WEST SUSSEX COUNTY COUNCIL CONSULTATION

TO:	Arun District Council FAO: Miss K Welch
FROM:	WSCC – Highway Authority
DATE:	8 November 2024
LOCATION:	Land at Toddington Lane Littlehampton BN17 7PN
SUBJECT:	LU/246/24/PL Demolition of existing structures and development of land to create 10 No. residential dwellings, landscaping, access, car parking and cycle parking. This application may affect the setting of listed buildings, is in CIL zone 2 and is CIL liable as new dwellings.
DATE OF SITE VISIT:	29 October 2024
RECOMMENDATION:	More Information Required

## APPENDIX C – Proposed Site Plan

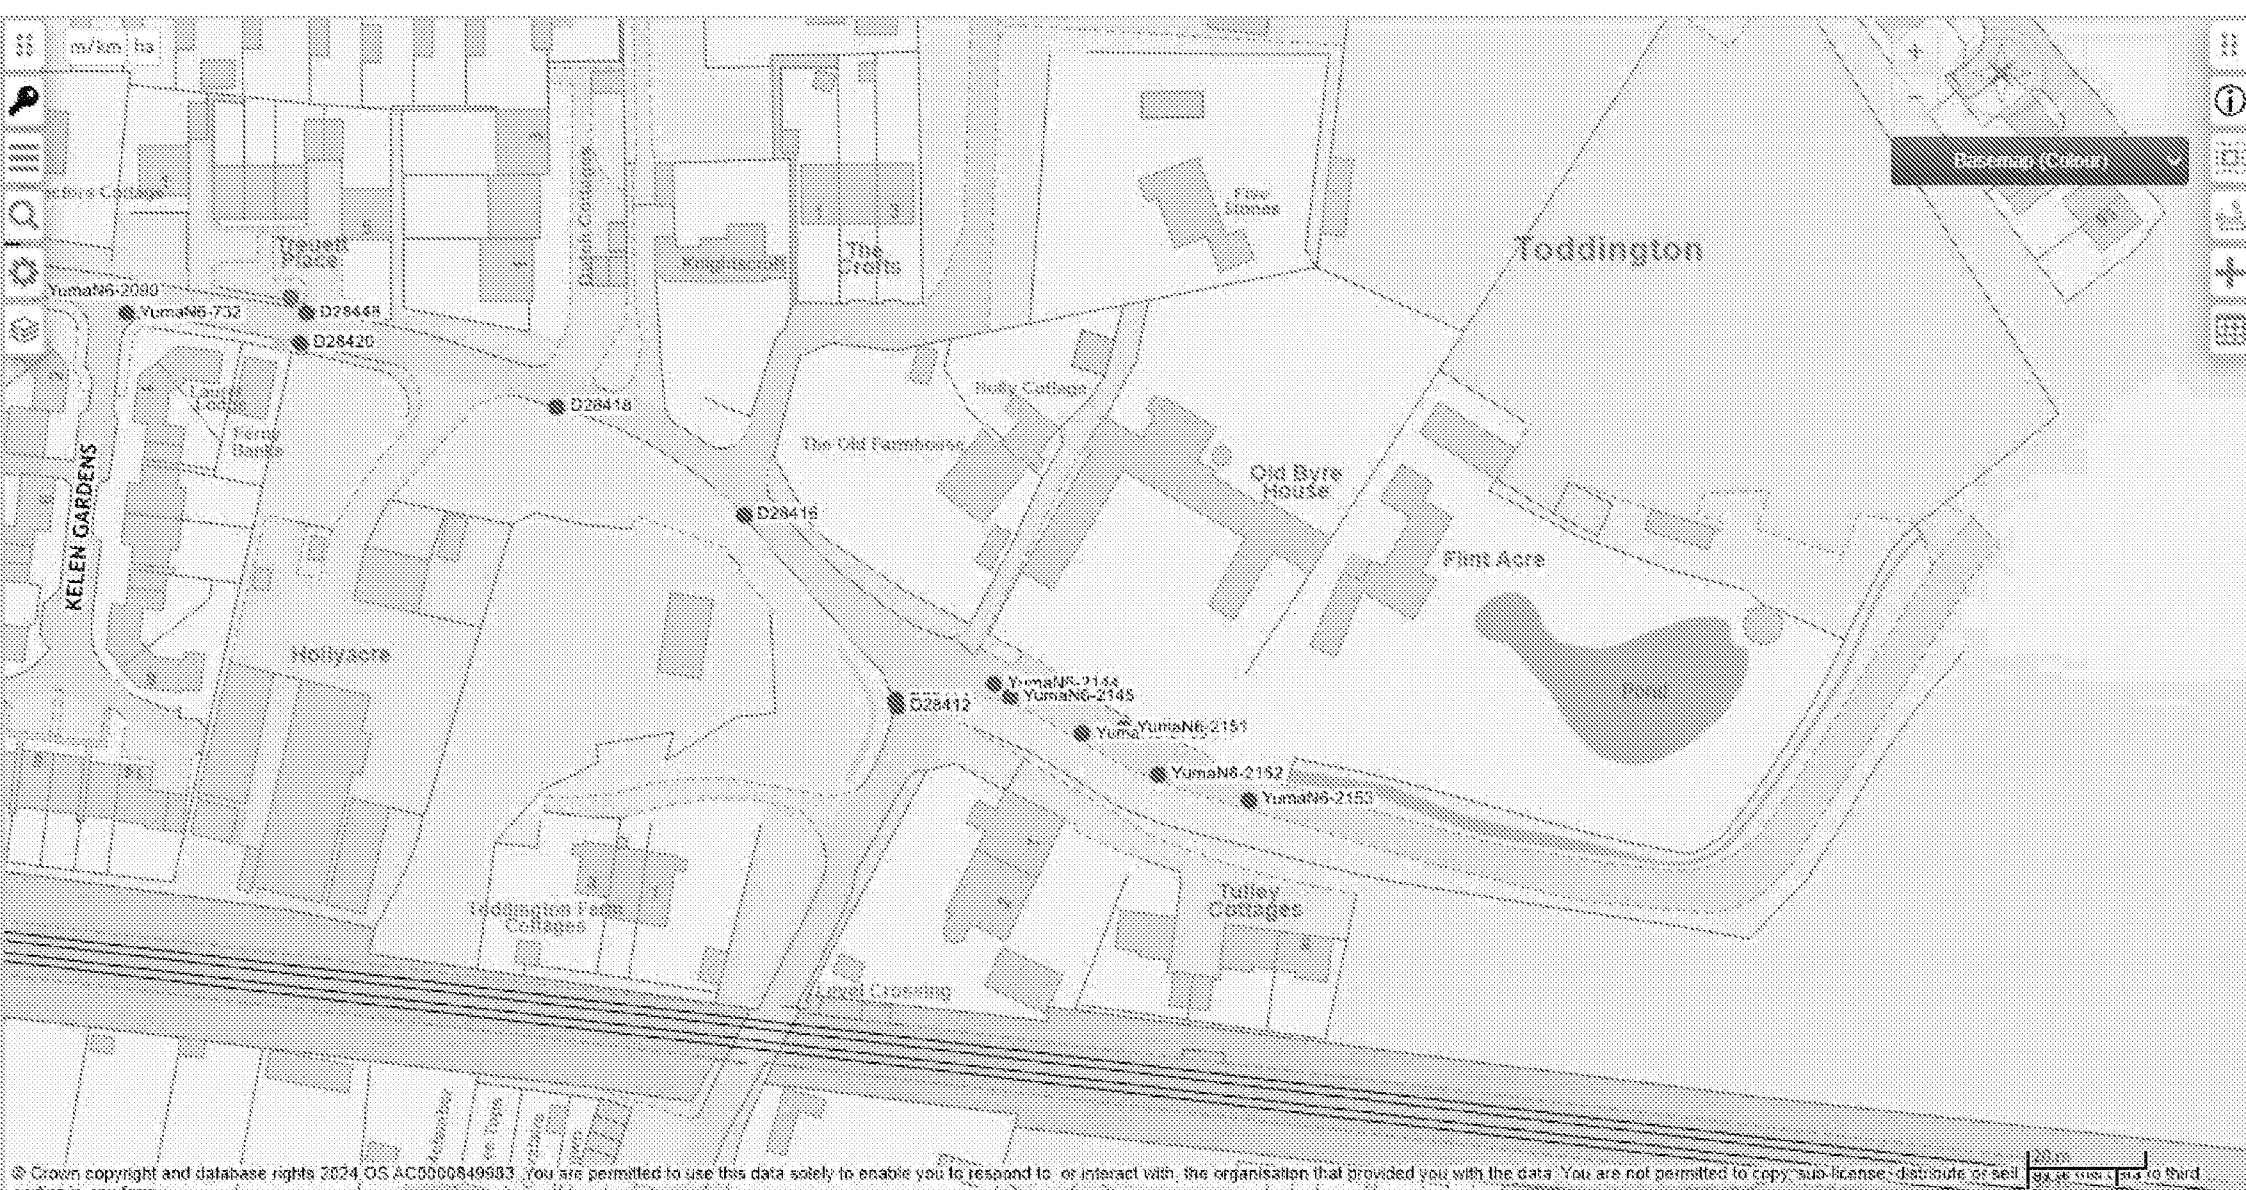
Access is shown to the north-south section of Toddington Lane via a simple junction with bellmouth radii. However, visibility splays have not been shown. Applicant to provide a plan showing these. Additionally, a rumble strip should also be provided close to the junction with Toddington Lane to warn drivers that they are entering a shared surface road. Careful design should be given to this to ensure that the needs of blind or partially sighted people are not prejudiced.

view that allocation of some of the parking spaces is/are not close to, or in front of, the properties they are expected to serve, particularly with regard to plots 1, 4, 7 and 8. This will lead to confusion and potential problems in practice if constructed like this. As such, the applicant should amend this, making spaces as close to the properties to which they are intended to serve.

Additionally, a further visitor space should be considered, perhaps being located just south of plot 1 on the internal access road.

And, finally on the car parking side of things, what provision (including visitor provision) is to be made/retained for the existing cottages south of the proposed access road?

Having looked at the layout and also destinations that residents might seek to travel to on-foot, such as community centre/facilities and a school, it is recommended that a footway be provided from the vehicular access to the development, along its eastern boundary facing Toddington Lane and up to the footway proposed as part of the

Greencore scheme. The footway, at the point it enters the new development, should terminate just beyond the aforementioned rumble strip.

1. Visibility splays to be shown at site entrance commensurate with Manual for Streets advice based on both existing and proposed Toddington Lane configurations.

3. Layout amendment to include a rumble strip at the entrance to the site.
4. Layout amendment to show a footway on Toddington Lane, taken from the site access and running N and S along the western-side of Toddington Lane, connecting to the one proposed by Greencore/Persimmon.

5. Parking amendments as-per description in main text above, plus consideration of additional visitor parking space.
6. Provision of details of parking for existing cottages south of the site, plus visitor provision.

- 7. Plan to show a selection of vehicles (including HGVs) using the access onto Toddington lane for turning.**
